Application No: FP/32/21/PL
Site Address: Land adjacent to 10 Second Avenue Felpham PO22 7LJ
Description of works: Two storey, 4 Bed detached dwelling with new access & parking. This site is in CIL Zone 4 & is CIL Liab as new dwelling.

Thank you for your internet representation made on 17th March 2021 which has been recorded as no objection with the comments as follows:

Proposed development at "10" Second Avenue - Planning ref FP/32/21/PL

PROPOSED ELEVATIONS

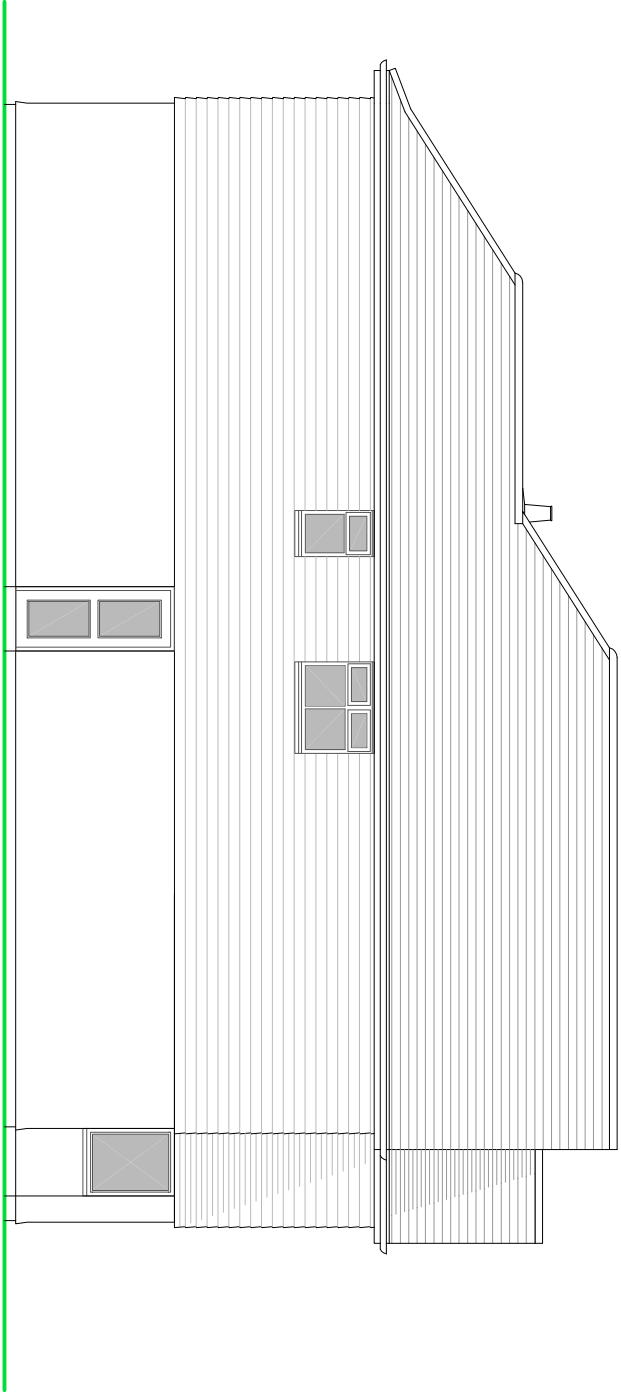
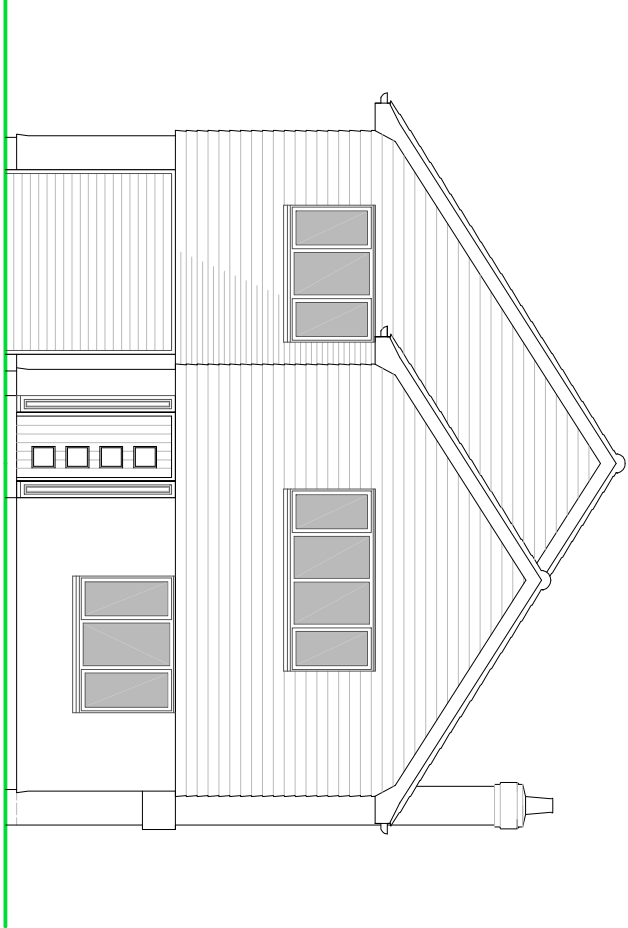
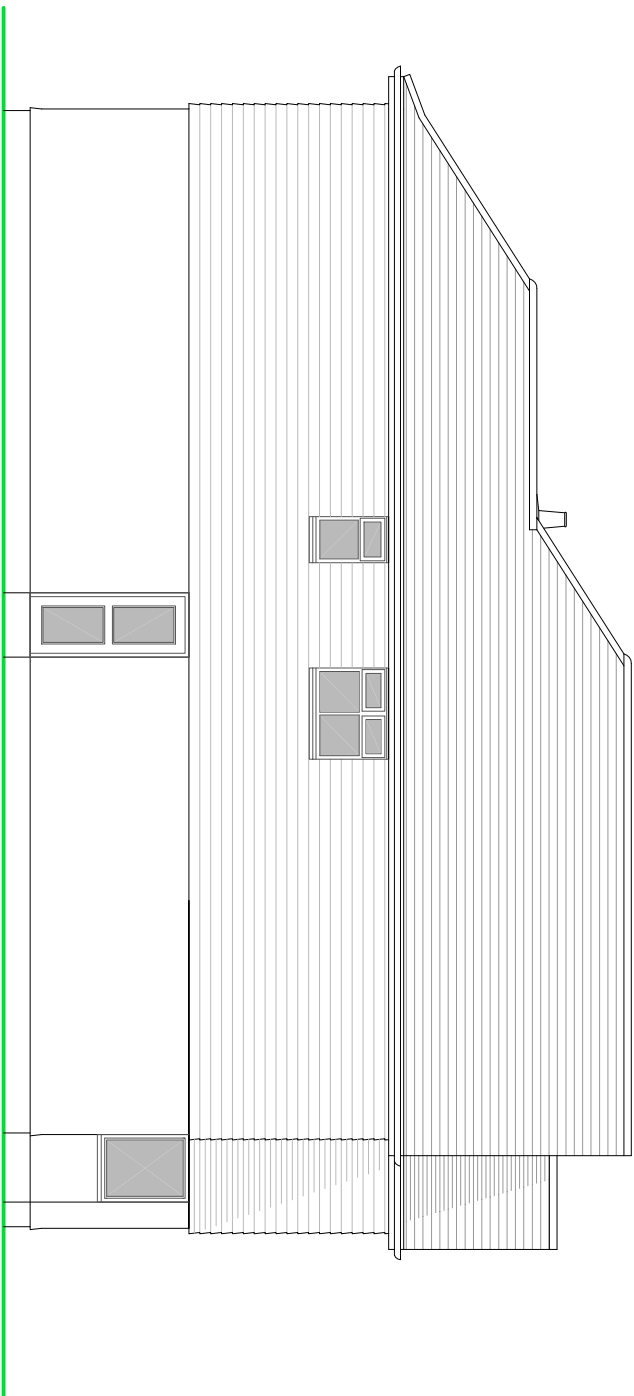
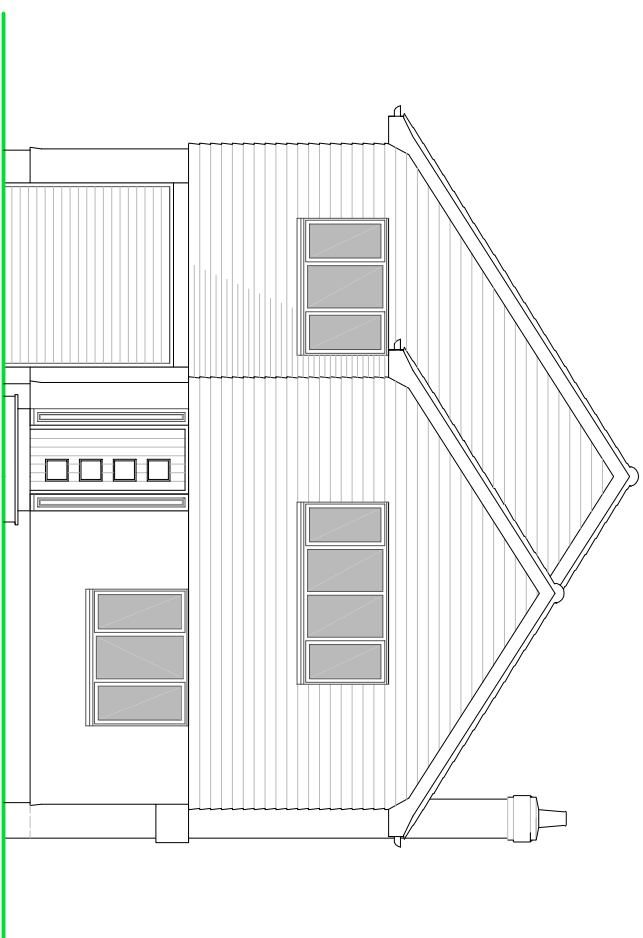
Architecturally, the elevations replicate the adjoining houses Nos 8 & 9, that were built in the 1960's. Every other house in that road has a distinctive design. (which is a requirement dating back to the sale of plots in the 1930's). In our opinion another New England style is unimaginative, and more effort should be made to achieve a distinctive and unique roadside elevation, in keeping with road and the immediate neighbourhood. A good example of what could be achieved on the front elevation is demonstrated by the development of Jacken Close, where houses are similar but finished details brings distinct differences.
